From: Andrew Wood <Andrew.Wood@arun.gov.uk>
Sent: 21 November 2019 09:29
To: Planning.Responses <Planning.Responses@arun.gov.uk>
Subject: FW: WA/7/19/RES - Lanes End, West Walberton Lane - Additional information request

From: Mark Warwick <Mark.Warwick@arun.gov.uk>
Sent: 23 October 2019 13:02
To: Andrew Wood <Andrew.Wood@arun.gov.uk>
Subject: RE: WA/7/19/RES - Lanes End, West Walberton Lane - Additional information request

WA/7/19/RES - Lanes End, West Walberton Lane - Additional information request

PLOTS 1 AND 2 FLOOR PLANS AND ELEVATIONS

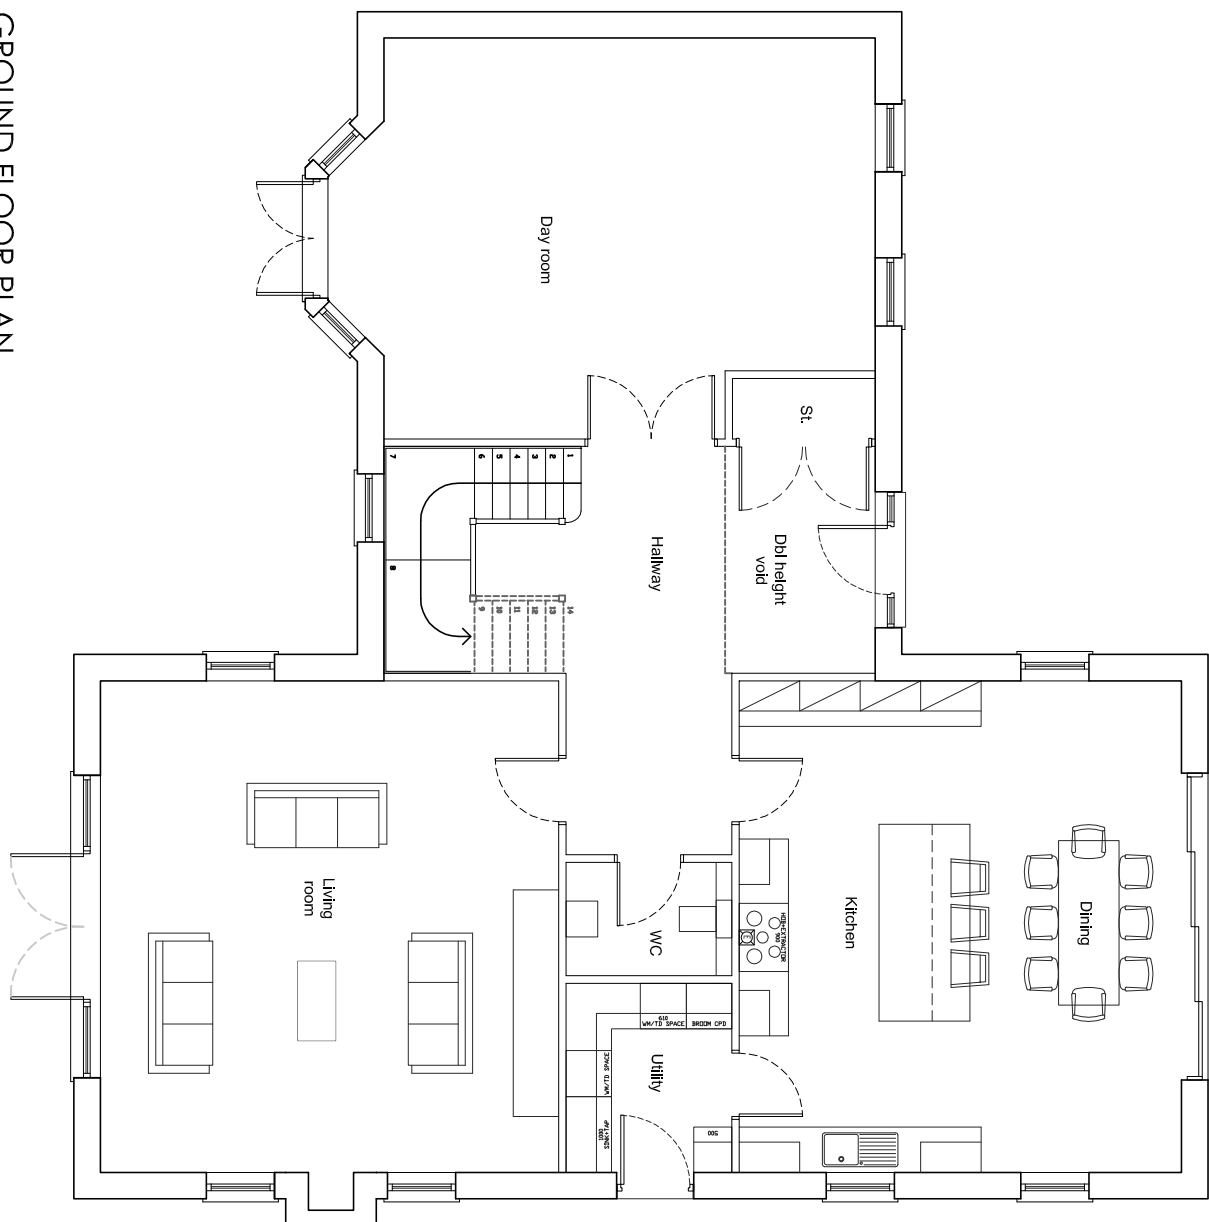
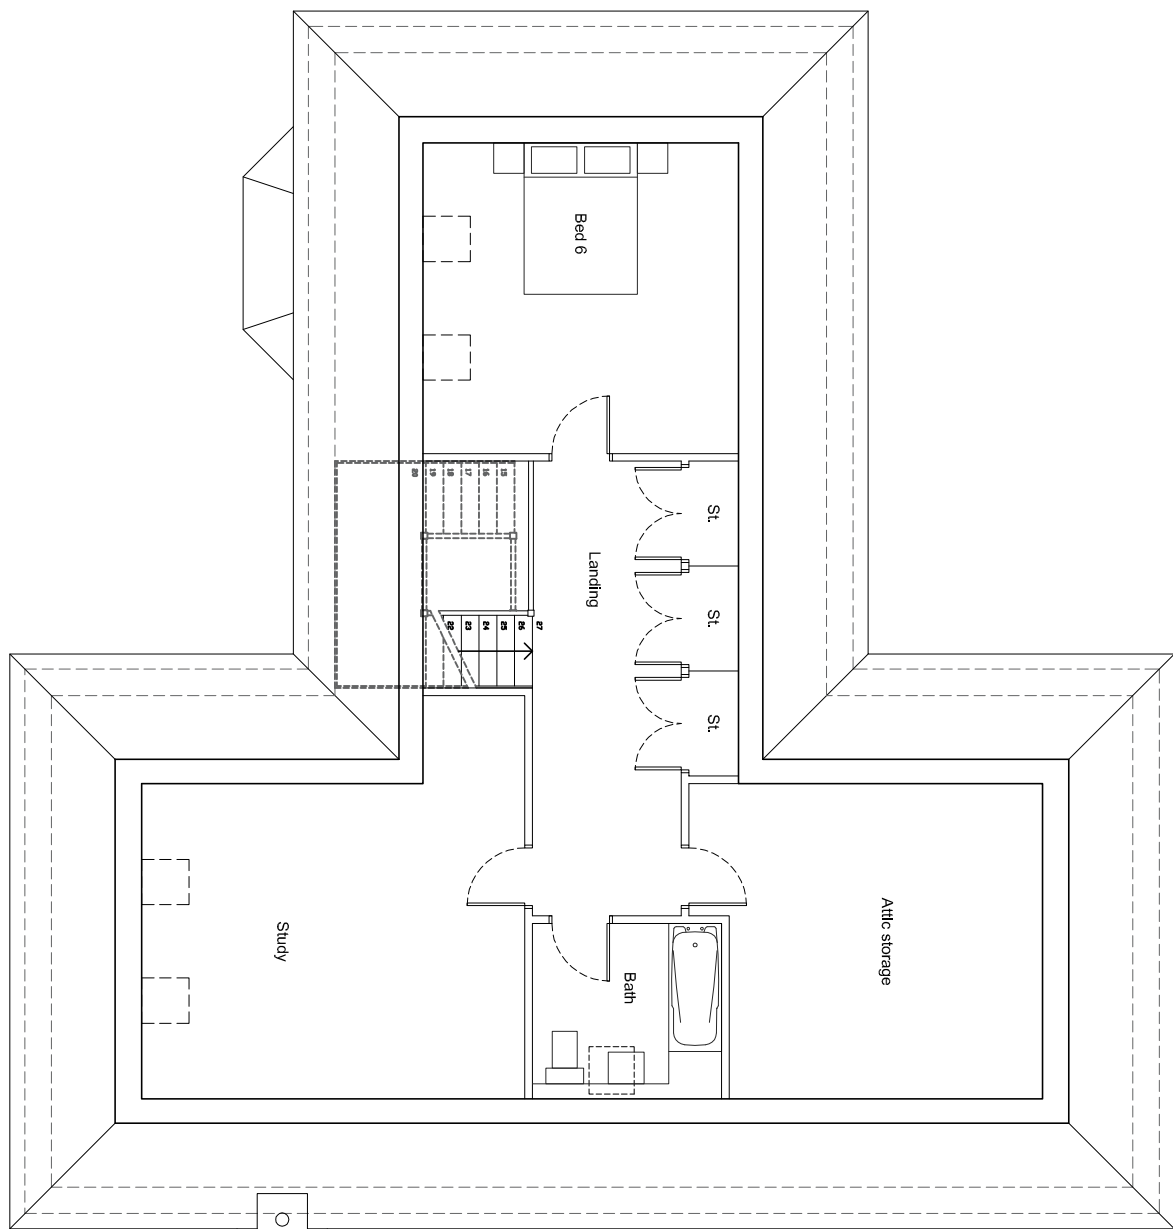
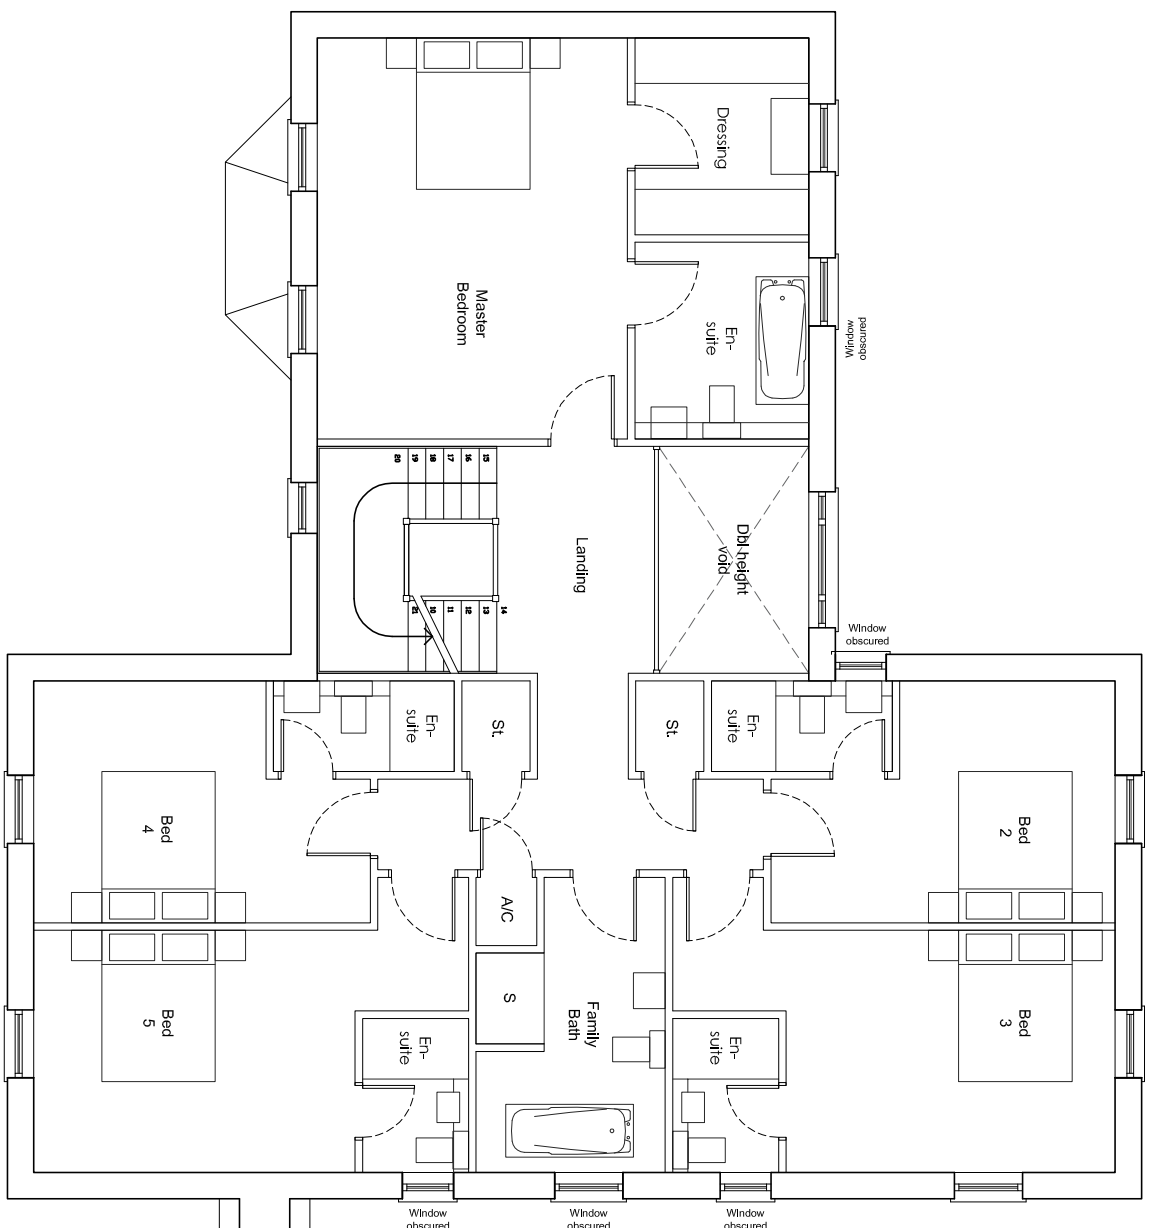
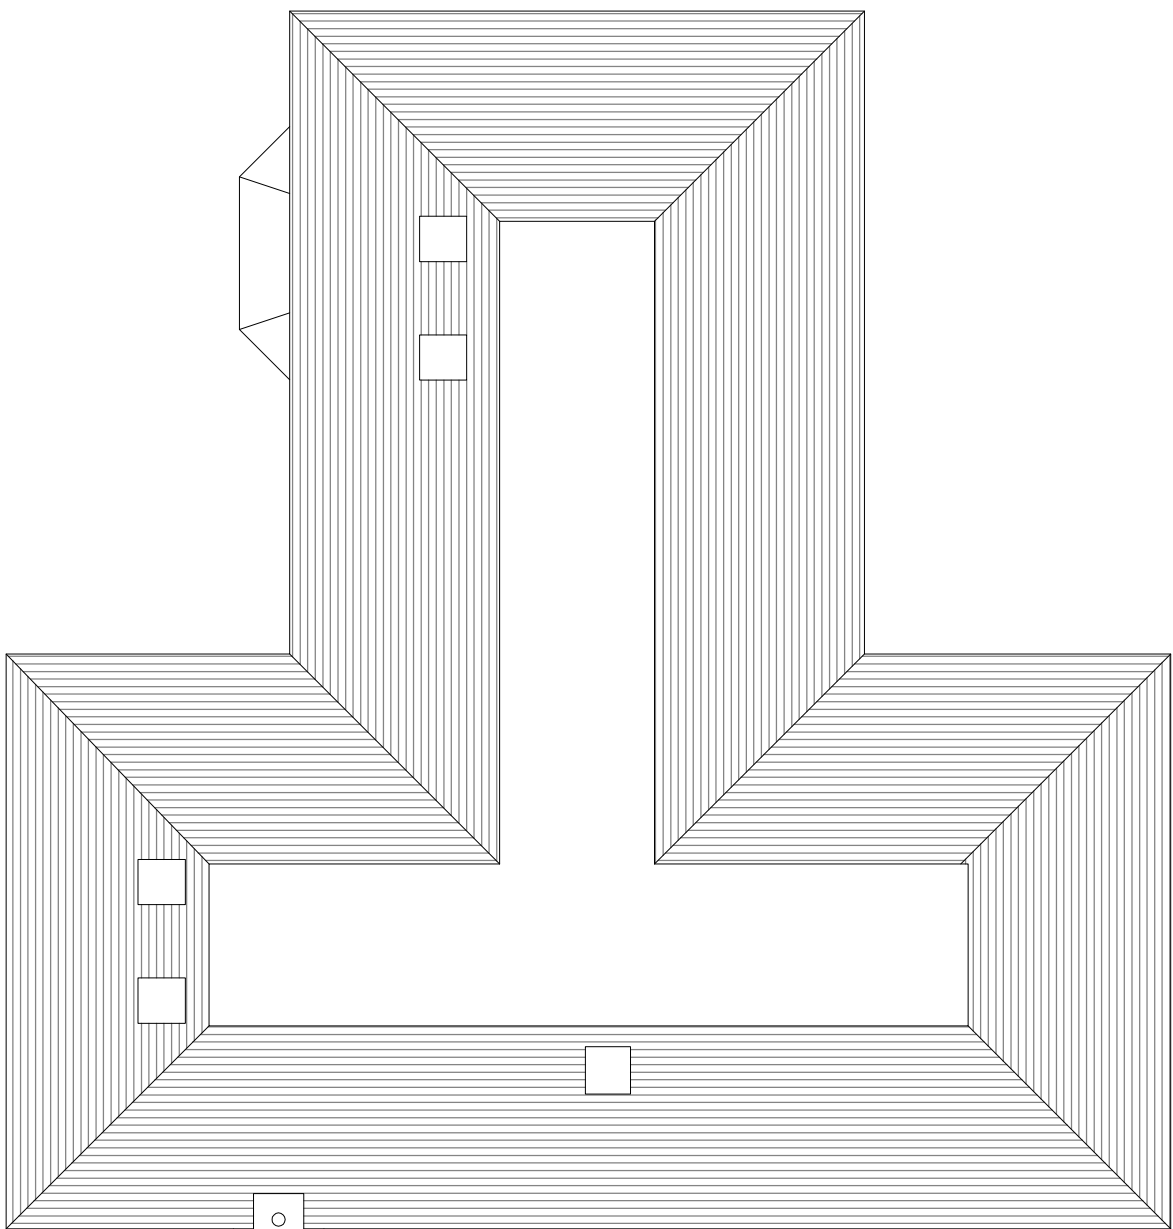
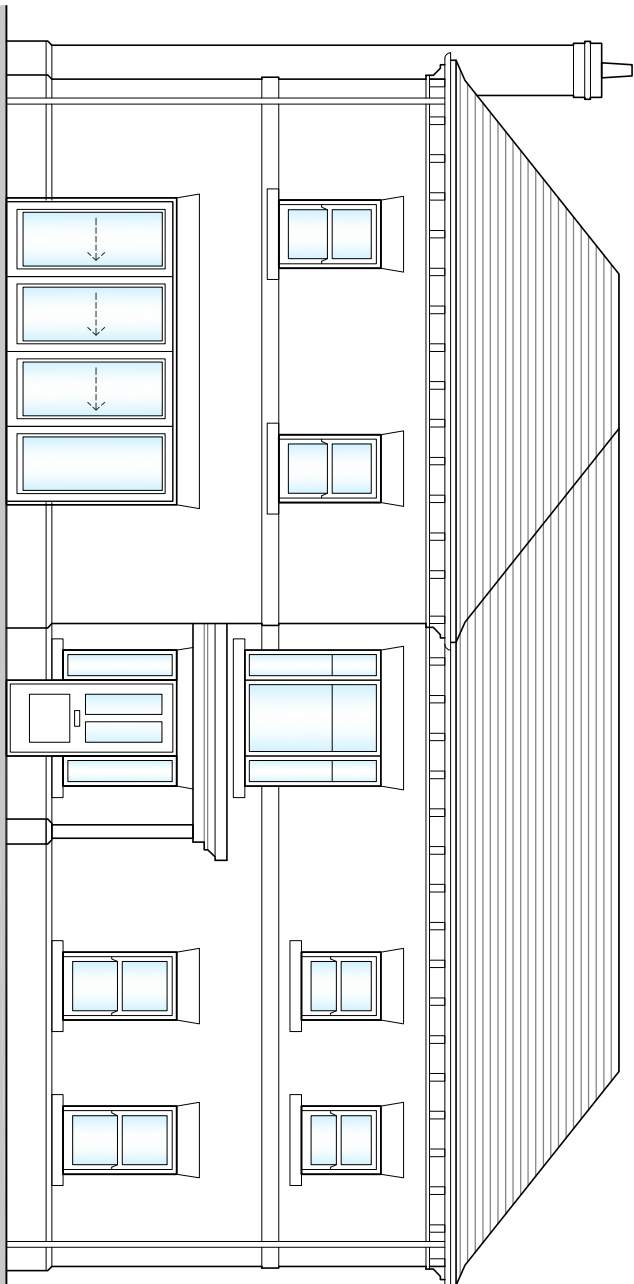
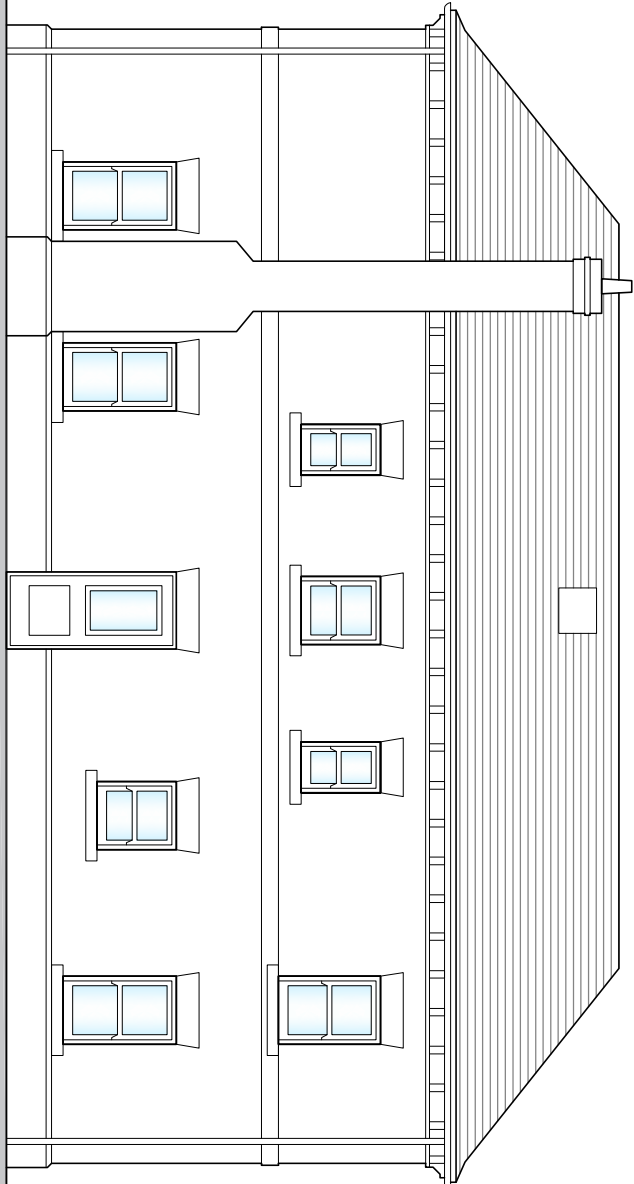
the issue with the rooms in the roof is that the appearance of the dwellings will be of a town house which is simply not appropriate in this location. I would strongly advise you to remove this element from the scheme. To avoid the risk of the development being viewed as 'out of character' in the area and contrary to policy D DM1 of the Arun Local Plan. I have discussed the matter with my line management team and everyone is of the same view in this case.

1. Amend the layout to ensure that a minimum of 9 metres exists on from blank gable end (or obscure glazed windows non opening below 1.7 metres in height) of nearest proposed house to gable end of 'Woodlands' which currently incorporates sole habitable room windows.
2. Remove second storey of houses/rooms in roof. 3 storey townhouses would not be acceptable in this location

2, we fail to see the merit in removing the room in the roof, this would have no impact on the height of the buildings and would result in empty lift spaces which would not allow for good use of space as per the NPPF. You will note from drawing 19-001-PL-03 all the dormers on houses 3-6 are in the south and therefore can not be seen from the front or any point outside the properties. Currently prosperities one and two have the dormers on the north but I would be happy to move these to the south so these are the same and none can be seen from Arundel road. I also would like to mention the design of white cottage next door that will have dormers in the roof and Richmond house which has velum windows in the roof. As previously mentioned the new ridge heights will be lower than the current house at Lanes end this can be seen in the scale drawings provided. If you could let me know if this is acceptable as if possible to avoid I would prefer not to have to appeal the reserved matters for this small item.
